Sea Link

Document 9.29 Draft Statement of Common Ground Between National Grid Electricity Transmission and the Environment Agency.

Planning Inspectorate Reference: EN020026

Version: A
January 2026

Plate 2.3 Infrastructure within fluvial flood extents

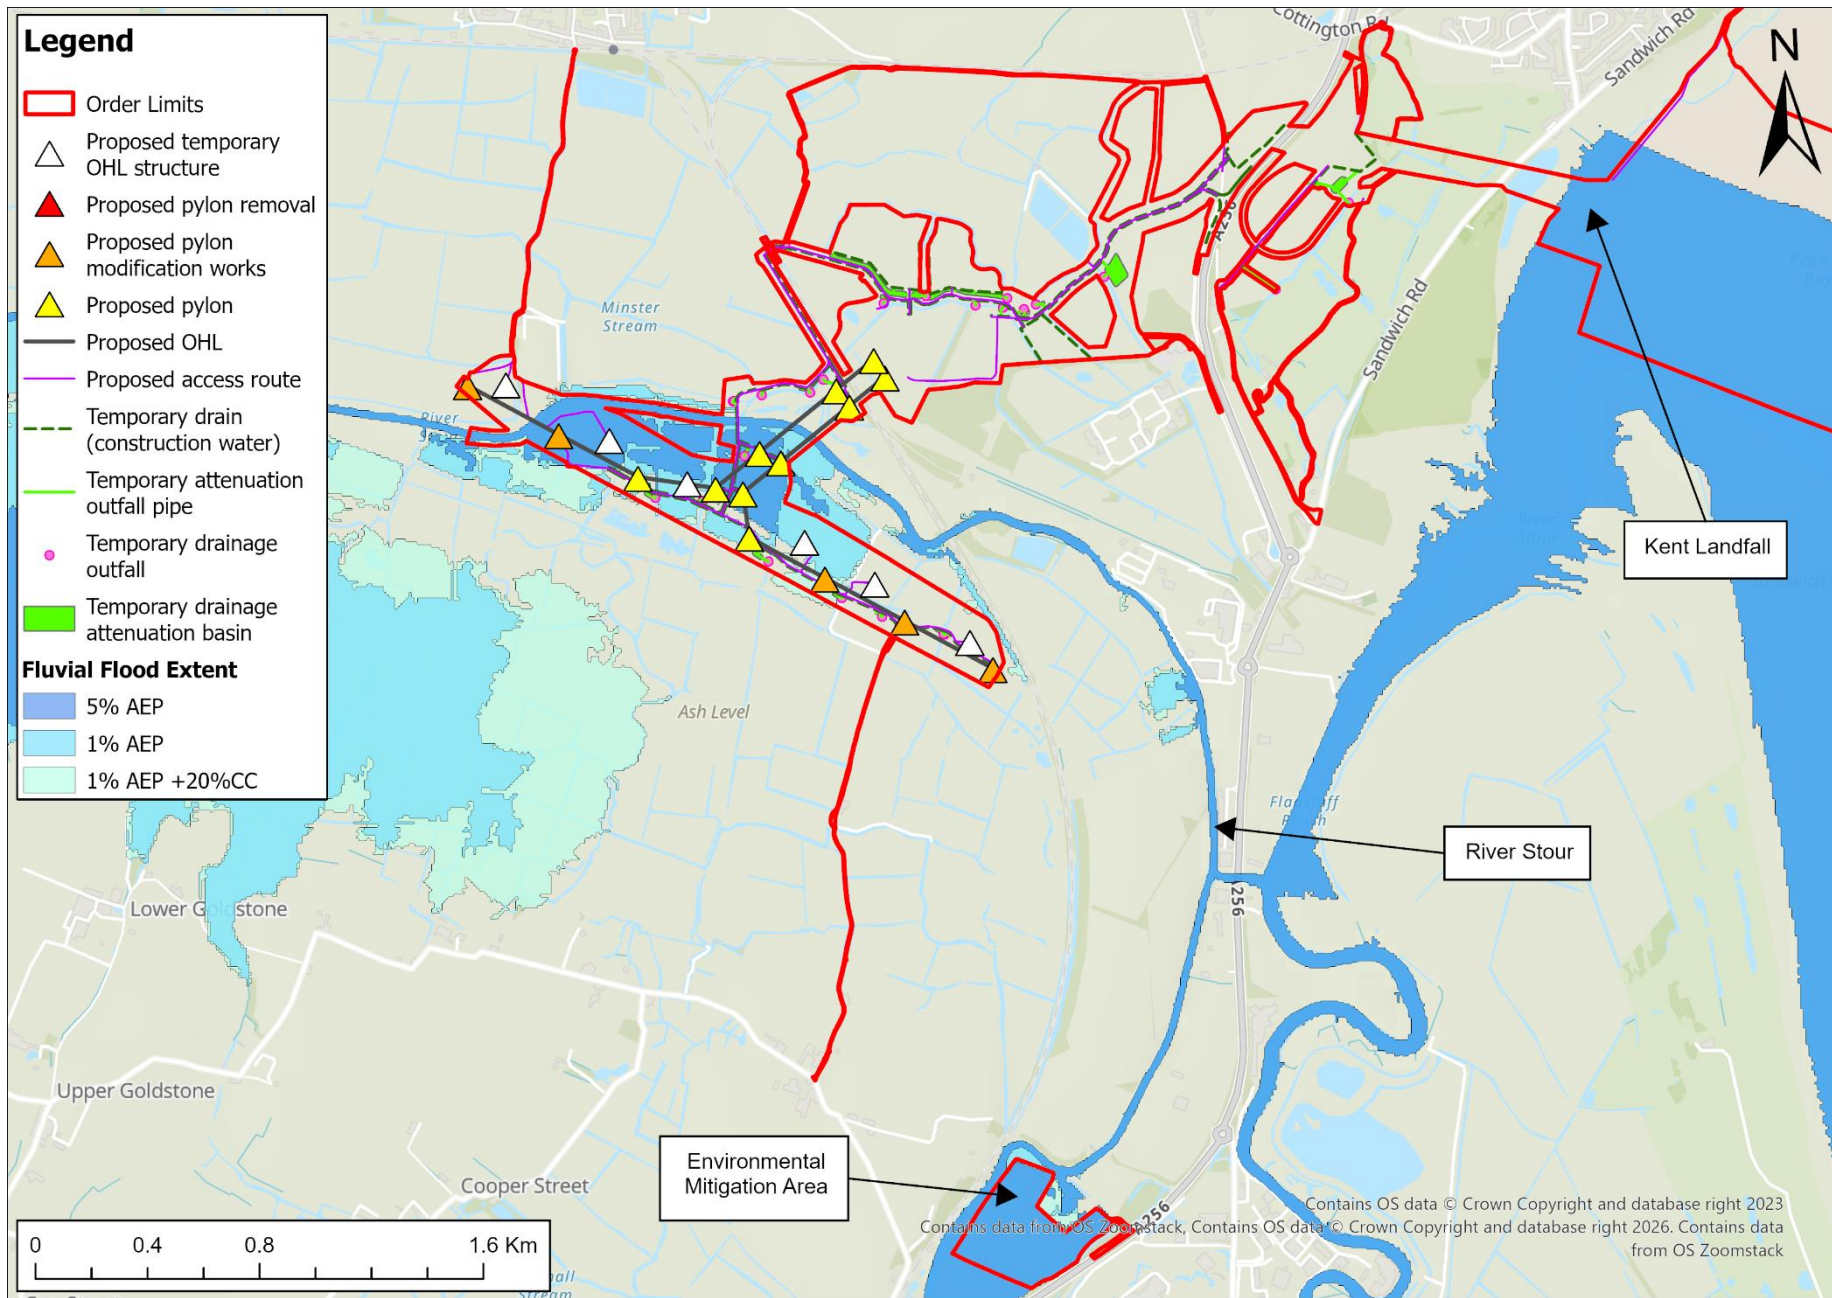
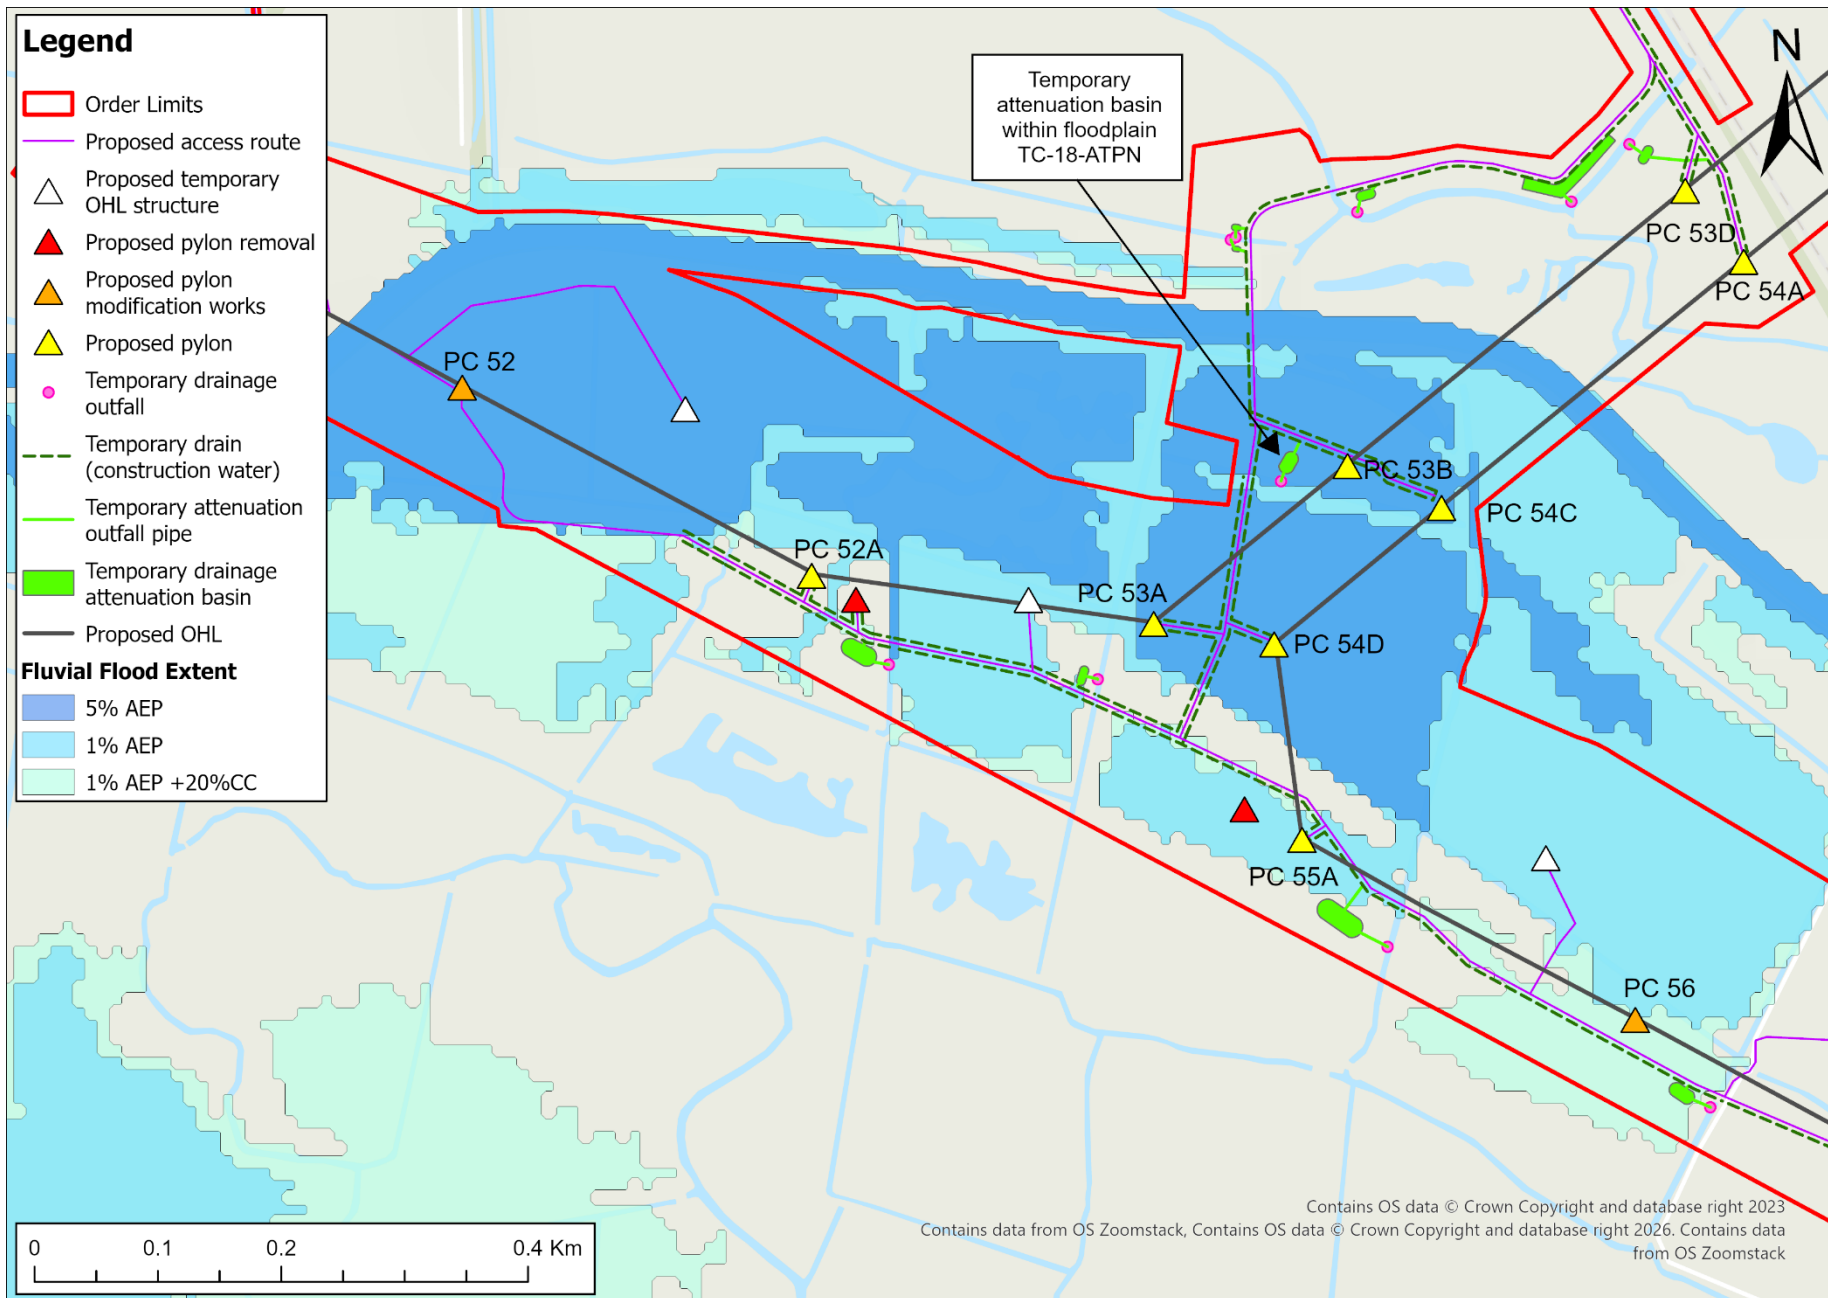
Ref	Relevant Application Document	Description of Matter from Work Package Tracker	EA Issue from RR	National Grid Current Position	EA Current Position	Status
				Within the floodplain of the River Stour works to overhead line towers are proposed, including erection of new Overhead Line Towers, works to existing Overhead Line Towers and the dismantling of Overhead Line Towers. These works are classified as essential infrastructure which is deemed in the NPPF Technical Guidance an appropriate and justified use within Flood Zone 3b. It is therefore concluded that inappropriate development within the functional floodplain is not proposed.	new overhead line towers are to be constructed within the fluvial floodplain, then the Applicant should consider if and what flood compensation may be required. Please see EA069 and EA089 for more details on the River Stour floodplain.	
EA066	APP-292 6.8 Flood Risk Assessment	EA066: Medium flood risk noted during construction without clear location or specifics.	Areas at high and medium risk of flooding from surface water sources, as defined by the updated National Flood Risk Assessment 2 (NaFRA2) datasets published in January 2025 are illustrated in Plates 2A to 2D in Application Document 6.8 Flood Risk Assessment Appendix A [APP-292] . Separate figures are included for the construction and operational phases of the Suffolk and Kent Onshore Schemes. Areas at high and medium risk of fluvial flooding (represented by Flood Zone 3) are illustrated in Plates 1A to 1D in Application Document 6.8 Flood Risk Assessment Appendix A [APP-292] . Separate figures are included for the construction and operational phases of the Suffolk and Kent Onshore Schemes. Mitigation for works within these zones are detailed in Table 1.1 of Application Document 6.8 Flood Risk Assessment [APP-292] .	We cannot resolve this issue at this point in time. There is a statement in Ex 1.3.2 within Application Document 6.8 Flood Risk Assessment [APP-292] that: " <i>With these measures in place, the residual risk of flooding during the construction phase has been assessed as low risk for all sources, except where it locally increases to medium.</i> " We note that this relates to all sources. It is unclear as to where the flood risk has been increased during the construction phase from low to medium. It needs to be made clear that flood risk should not increase, so we require the Applicant to change the wording.	We cannot resolve this issue at this point in time. There is a statement in Ex 1.3.2 within Application Document 6.8 Flood Risk Assessment [APP-292] that: " <i>With these measures in place, the residual risk of flooding during the construction phase has been assessed as low risk for all sources, except where it locally increases to medium.</i> " We note that this relates to all sources. It is unclear as to where the flood risk has been increased during the construction phase from low to medium. It needs to be made clear that flood risk should not increase, so we require the Applicant to change the wording.	Under discussion

EA083	APP-045 6.2.1.4 Part 1 Introduction Chapter 4 Description of the Proposed Project	Flood Risk Assessment Kent	EA083: Overhead line crossing over River Stour.	Where required, an update to Application Document 9.84 Register of Environmental Actions and Commitments (REAC) submitted at Deadline 3 will be made following further agreement between the Applicant and Environment Agency.	We do not consider this issue resolved. We asked that appropriate mitigation is in place within Document 7.5.3.2 CEMP Appendix B Register of Environmental Actions and Commitments (REAC) [APP-342] to ensure the River Stour is protected in relation to the overhead line crossing.	Under discussion

Plate 2.4 Potential floodplain compensation provision locations

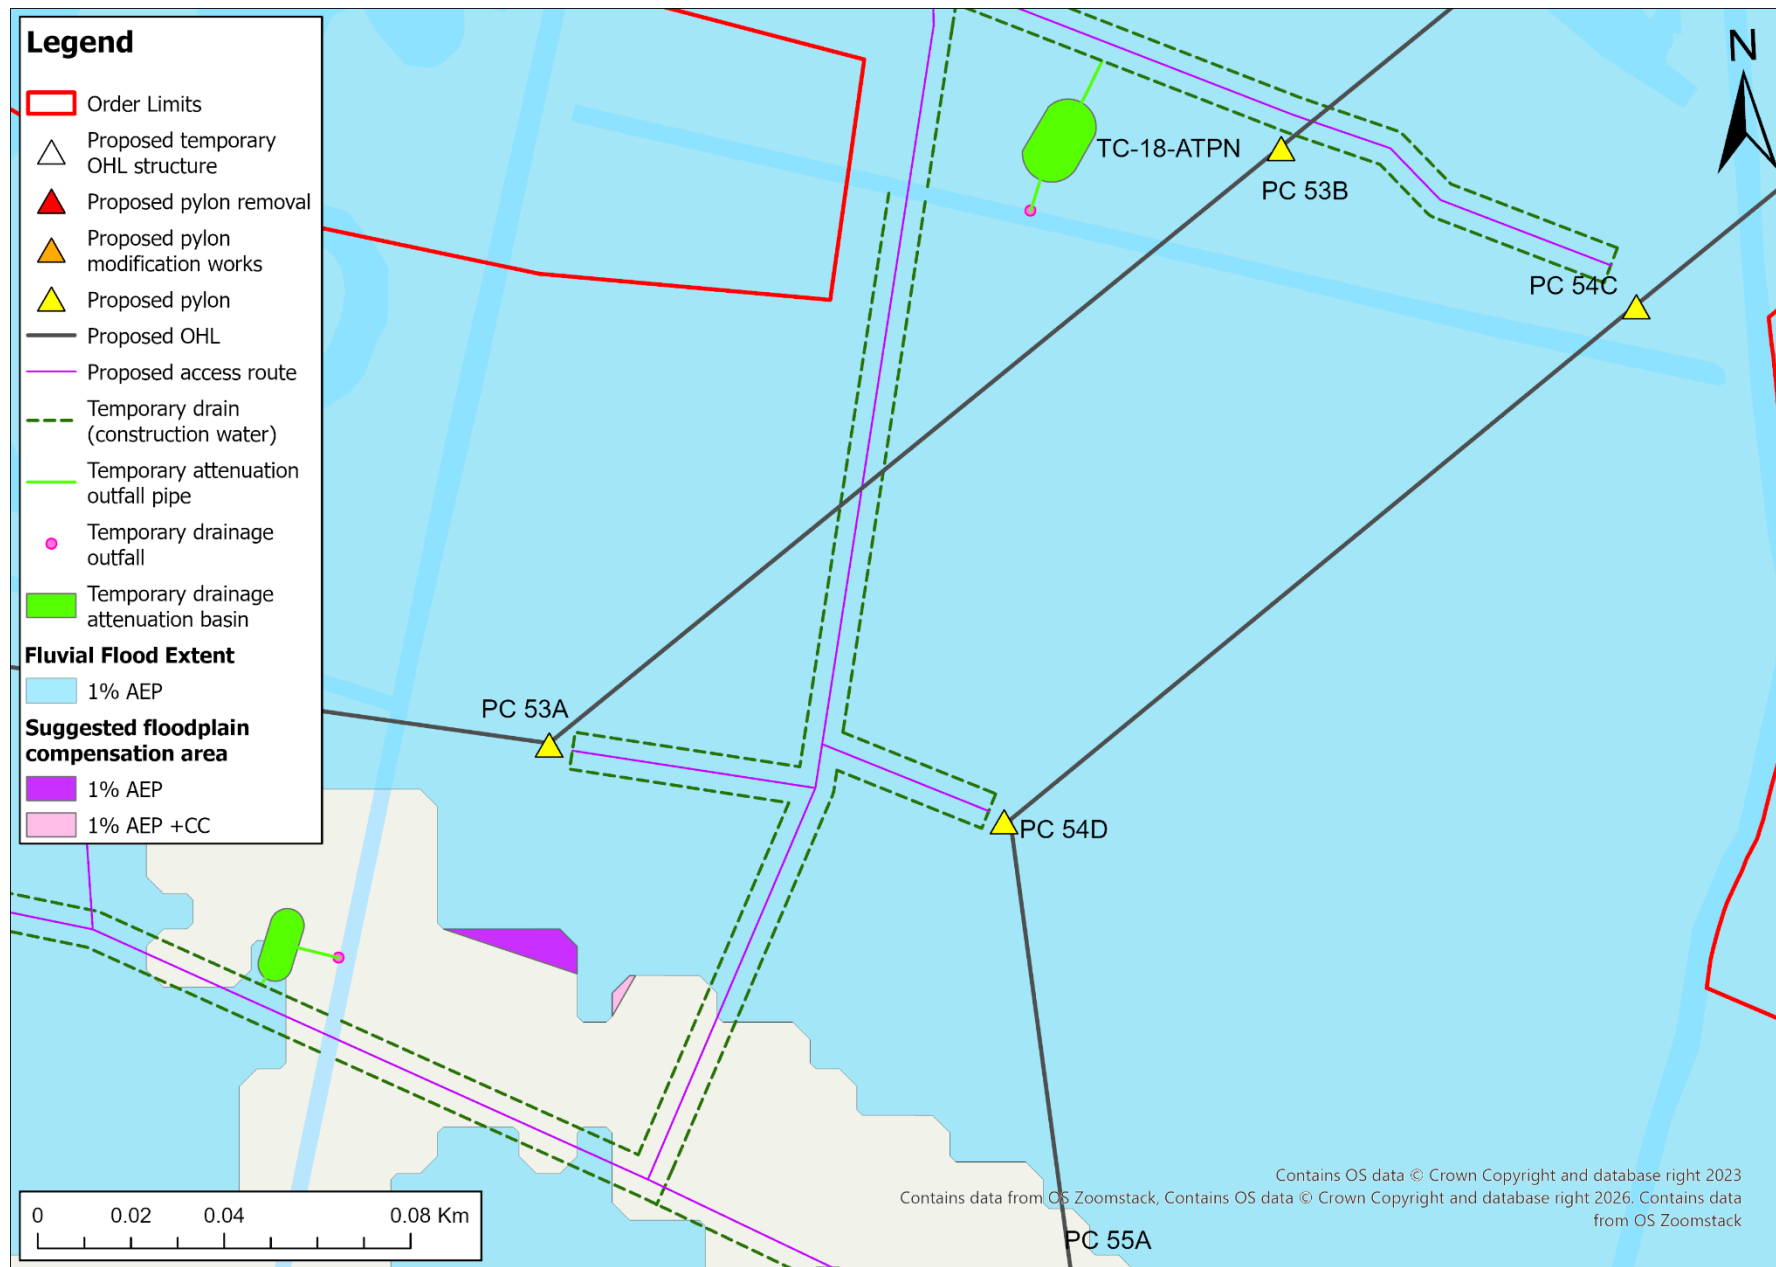
EA069	APP-292 6.8 Flood Risk Assessment		EA069: (W06) Construction material storage in Flood Zone 3 with ground raising, however there is no compensatory storage mentioned.	Commitment W06 commits to providing mitigations where temporary storage of construction materials in Flood Zone 3(a) cannot be avoided, limited to the River Stour floodplain. Examples include using model outputs to inform the placement of soil during construction and aligning soil stockpiles to avoid impeding key flood flow routes. Given that the River Stour is a tidally dominated river within the Order Limits, in accordance with the guidance that accompanies the National Planning Policy Framework compensation for losses of	We do not consider this issue resolved. We have identified that the River Stour floodplain within the boundary of the scheme is fluvially-influenced in areas, as well as having areas of tidal/fluvial crossover, and solely tidal influence. Of particular concern is the right bank floodplain of the River Stour between grid references 630950, 162775 and 632100, 162300 and additionally at grid reference 632650, 159900 as these areas fall within the defended fluvial floodplain, and	Under discussion

Ref	Relevant Application Document	Description of Matter from Work Package Tracker	EA Issue from RR	National Grid Current Position	EA Current Position	Status
					<p>Following this meeting, we stated to the applicant that we'd resolve this issue in regard to ordinary watercourses. We stated we would differ to the Internal Drainage Board (IDB) and Lead Local Flood Authority (LLFA), in regards to reviewing individual culvert design appropriateness for WFD water quality and flood risk respectively. No culverts were proposed for main rivers.</p>	
EA096	APP-064 6.2.3.4 Part 3 Kent Chapter 4 Water Environment	EA096: Outdated Flood Map for Planning data from 2023 is being used.	An exercise has been undertaken to compare the latest Flood Map for Planning dataset against the mapping used to inform Application Document 6.8 Flood Risk Assessment [APP-292] . The findings are detailed in Additional Submission 9.4 Supplementary Environmental Information – Flood risk assessment update [AS-099] . There have been no changes to mapped flood zones 2 and 3 in the new Flood Map for Planning dataset within the Order Limits of the Kent Onshore Scheme. The conclusions of the FRA are therefore valid. Within the Order Limits of the Suffolk Onshore Scheme there is one small change. This is associated with an increase in the mapped flood extent for a small watercourse that drains into the River Fromus, where one temporary drainage pond is now located in Flood Zone 3 (previously Flood Zone 1). As noted in response to EA094, design of the pond would factor in the potential for flooding and as a consequence there are anticipated to be no impacts on the Proposed Projects drainage standards in this location, nor any significant flood risk impacts. The conclusions of the FRA remain valid.	<p>We are satisfied and consider this issue resolved.</p> <p>We previously highlighted that the outdated Flood Map for Planning data from 2023 was being used.</p> <p>The Applicant has confirmed that they undertook an exercise to compare the latest Flood Map for Planning dataset against the mapping used to inform the Document 6.8 Flood Risk Assessment [APP-292]. The findings (detailed in Additional Submission accepted at the discretion of the Examining Authority – Applicant's response to the ExA's s89(3) letter 8 July 2025 & 5 August 2025 – 9.4 Supplementary Environmental Information - Flood risk assessment [AS-099]) are that there have been no changes to mapped flood zones 2 and 3 in the new Flood Map for Planning dataset, within the Order Limits of the Kent Onshore Scheme.</p> <p>The Applicant has confirmed that within the Order Limits of the Suffolk Onshore Scheme there is one small change. This is associated with an increase in the mapped flood extent for a small watercourse that drains into the River Fromus, where one temporary drainage pond is now located in Flood Zone 3 (previously Flood Zone 1). As noted in response to EA094, design of the pond would factor in the potential for flooding and therefore there are anticipated to be no impacts on the Proposed Projects drainage standards in this location, nor any significant flood risk impacts.</p>	Agreed
